From: Carla Thompson [<mailto:Carla.Thompson@Brown-co.com>]
Sent: 28 October 2015 15:33
To: Nicholas Coombes
Subject: Deadline 13 Representations on behalf of Mr Roger Everdell (our ref E975)

Representing my client Mr Roger Everdell I was able to participate in the draft DCO Hearing on Thursday 22nd October 2015. I write to confirm issues which were raised at that meeting by way of comments on the Ex A's draft DCO.

Drawing title: **WORKS PLANS REGULATION 5(2)(j) SHEET 14 OF 29**

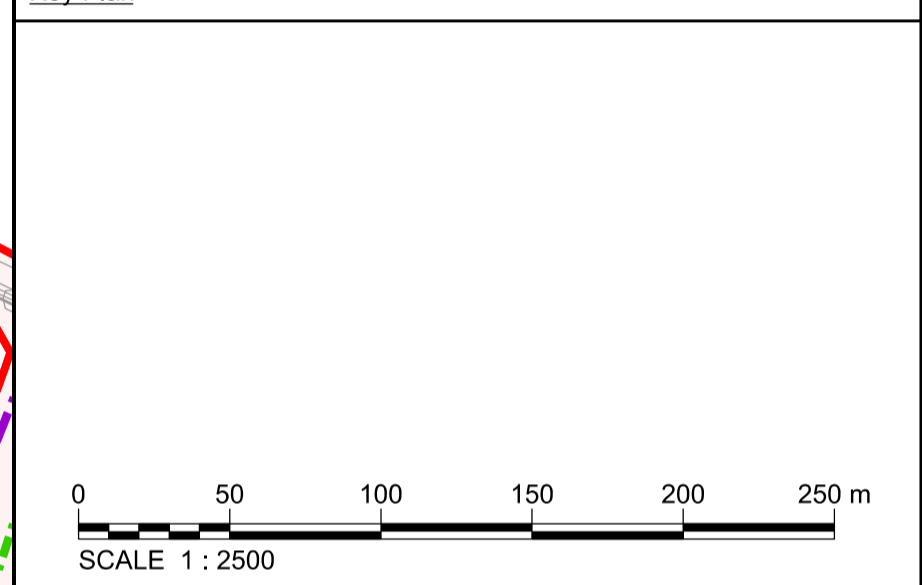
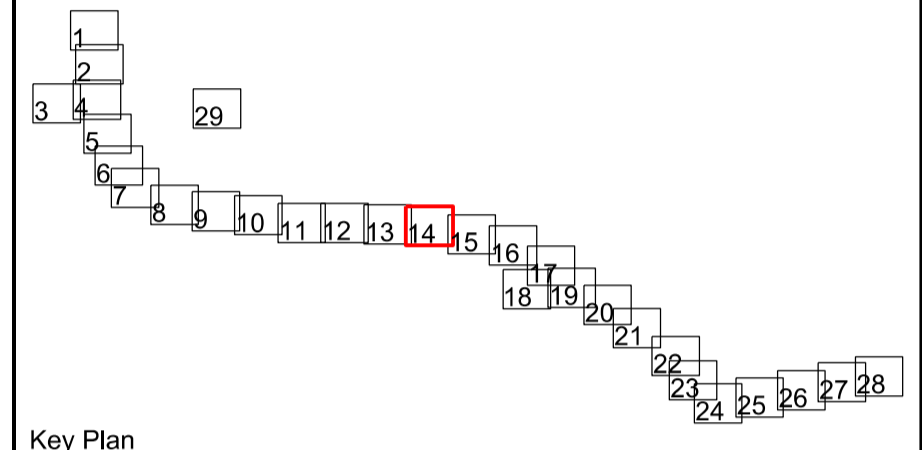
As an example and linked to my client Mr Everdell I have noted that the DCO with Schedule 10 as it is likely to appear will incorporate in respect of the northern section of Borrow Pit No. 3 (as owned by Mr Everdell) Works Plan Regulation Sheet 14 of 29 drawing No A14/ARP/ZZ/00/DR/Z/00214 and Sheet 13 of 29 in the same series. I am anticipating that engineering sections borrow pits Sheet 49 of 59 (Drawing No. A14-APR-ZZ-00-DR-Z-04049) will appear which will show the maximum depth of the borrow pit on my client's land as being 4.9m.

This coupled with Article 7 of the draft DCO which restricts limits of deviation gives a maximum depth of working on my client's land of $4.9\text{m} + 0.5\text{m} = 5.4\text{m}$.

My client has expressed concerns regarding the impact of de-watering on his adjacent domestic borehole water supply and on his adjacent fishing lakes.

As seems likely should at detailed design stage, it be established that there is a need to deepen borrow pit No. 3 to say 10m in depth, I asked the question as to how this will be achieved within the framework of the DCO and whether this would be a matter to which the Secretary of State would require to give approval at Schedule 2.
